Our ref: WA/2018/125672/01-L01
Your ref: 18/01363/F
Date: 12 September 2018

Improvement of community facilities compromising construction of disabled toilet, garage for community minibus, bi-fold door and patio.

Wendlebury Village Hall Main Street, Wendlebury, Oxfordshire, OX25 2PS.

# PROPOSED BUS GARAGE

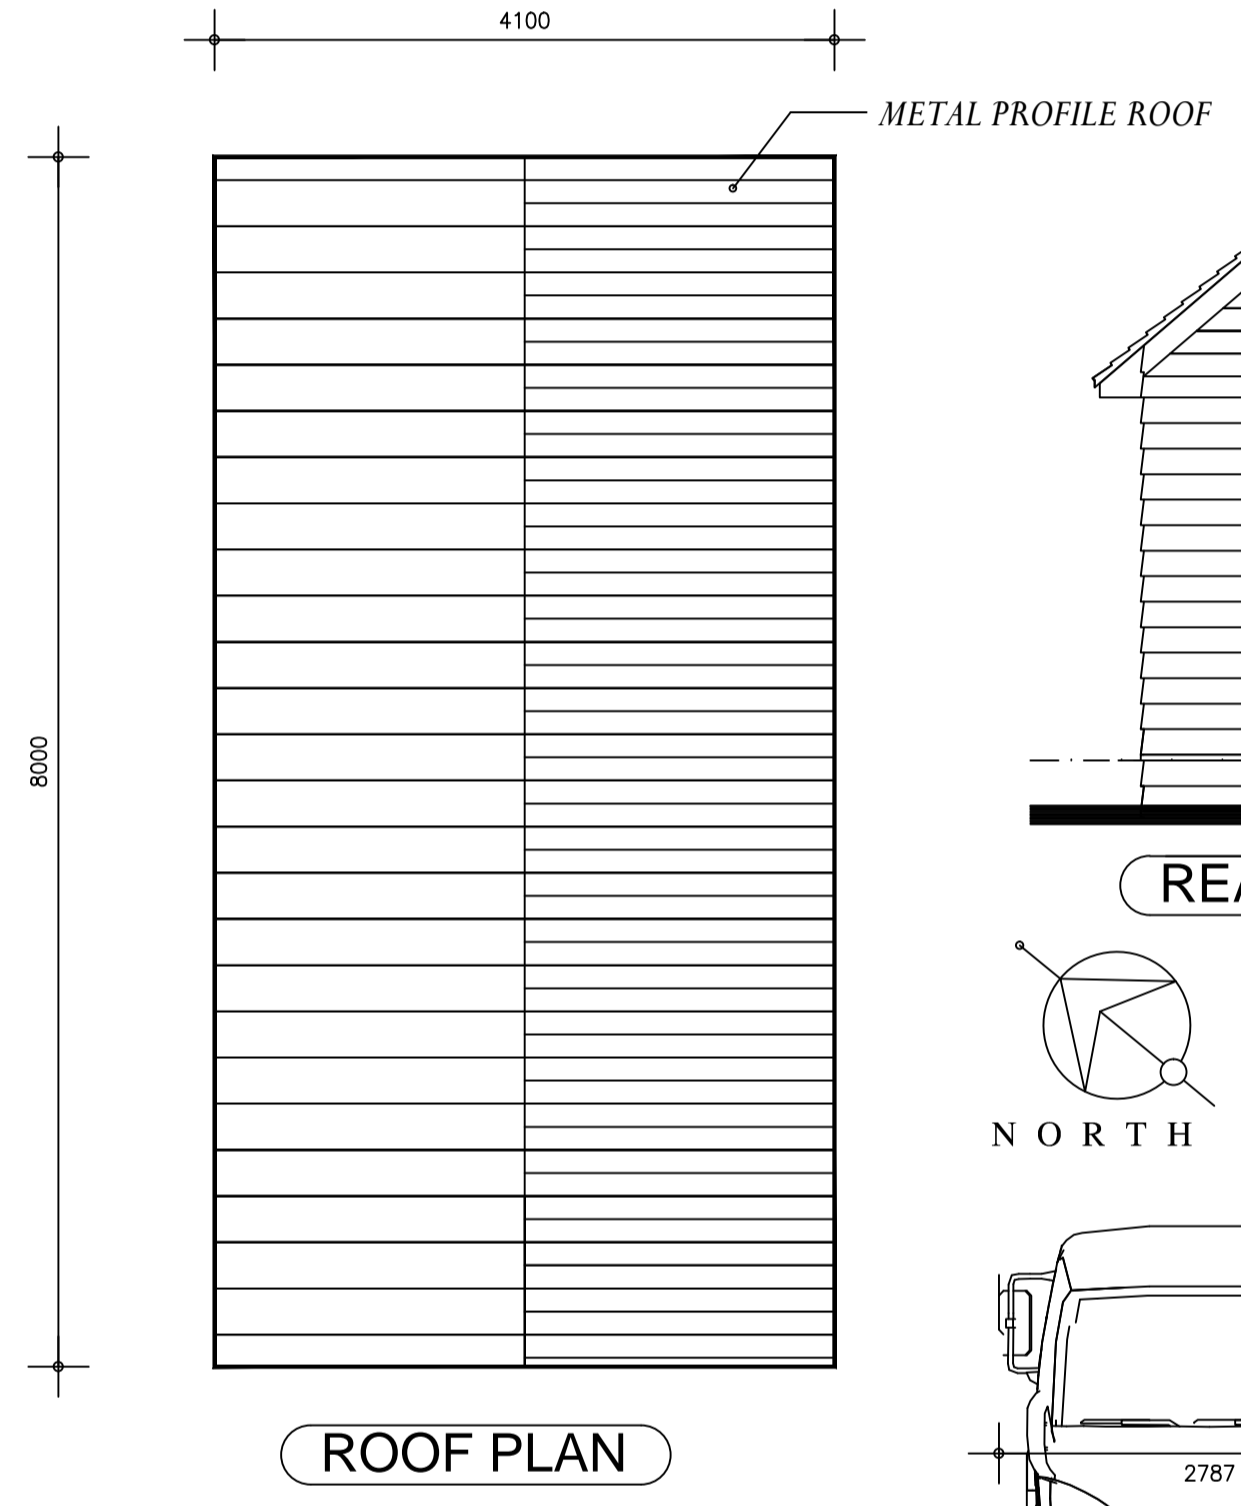
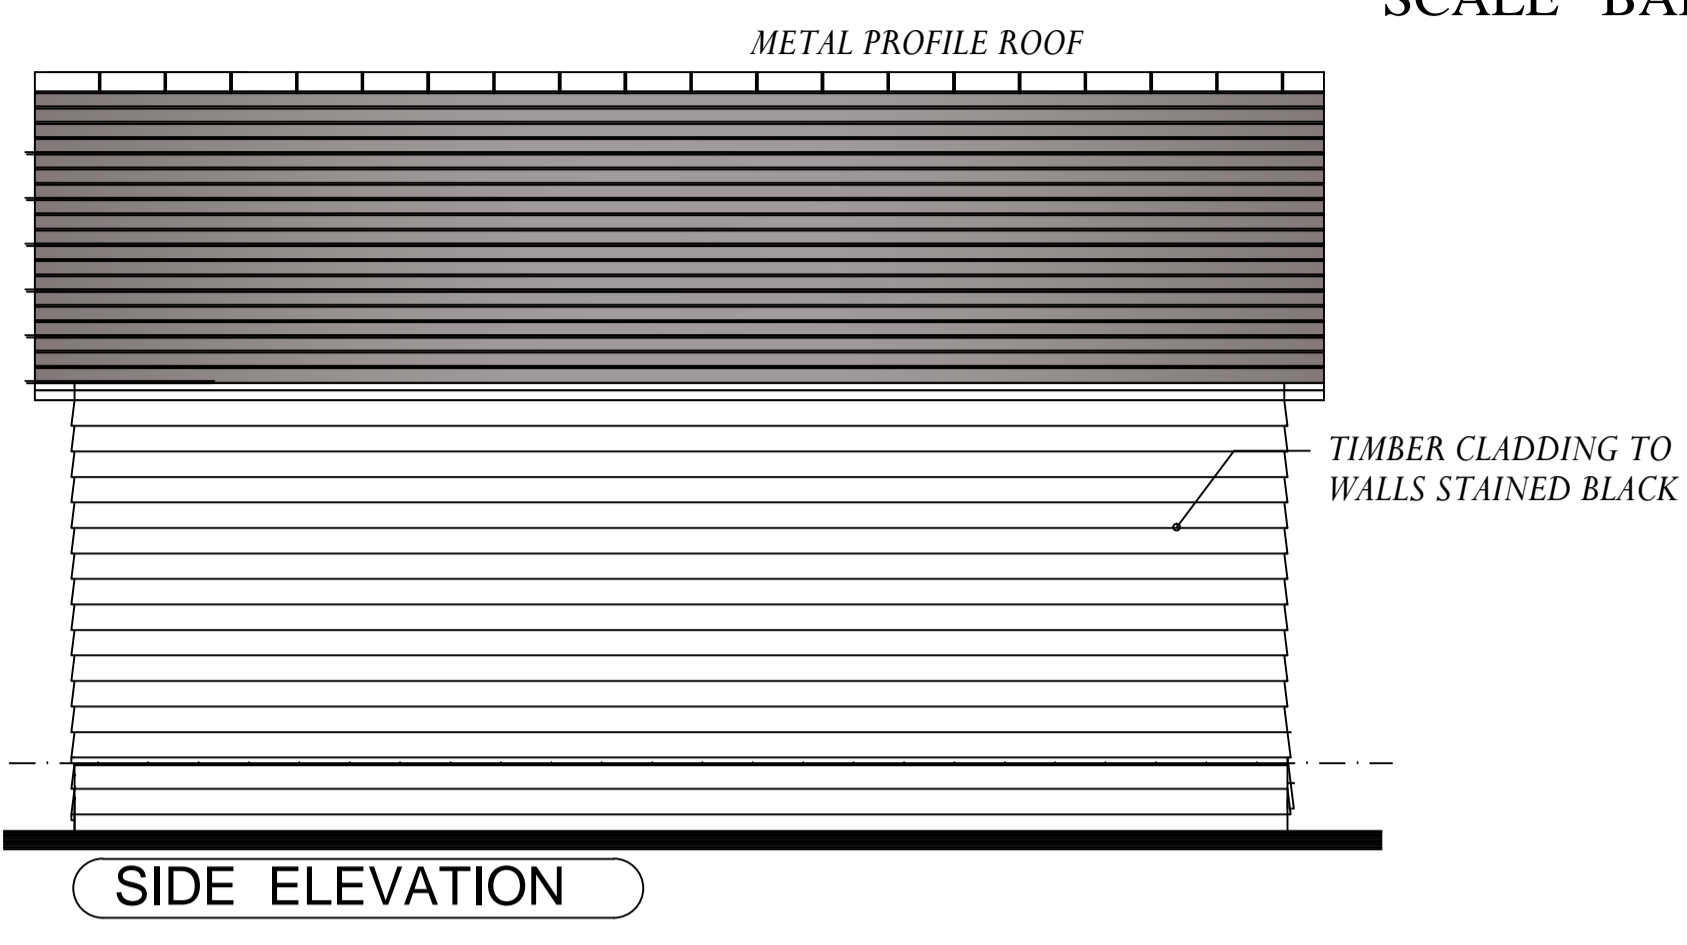
The application seeks approval to construct an extension to incorporate a disabled toilet, replacement of windows and small patio area and construction of a garage to house the Wendlebury Community Minibus. The proposed garage will increase the built footprint on site by 33sqm.

The proposed garaged is potentially located within the 1 in 100 flood extent with appropriate allowance for climate change, and therefore would need to be mitigated. The applicant should demonstrate whether the proposed garage is within the 1 in 100 flood extent or not.

The applicant should demonstrate that raised finished floor levels for the proposed development are set above the 1% annual probability (1 in 100) flood level with an appropriate allowance for climate change. This will reduce the risk of flooding to people and property.

The applicant can overcome our objection by submitting an FRA which covers the deficiencies highlighted above and demonstrates that the development will not increase flood risk elsewhere and where possible reduces flood risk overall. If this cannot be achieved we are likely to maintain our objection to the application.

Specifically, the FRA will need to demonstrate that any increase in built footprint within the 1% annual probability (1 in 100) flood extent with an appropriate allowance for climate change can be directly compensated for. This is necessary to prevent the new development reducing flood plain storage and displacing flood waters, thereby increasing flood risk elsewhere.
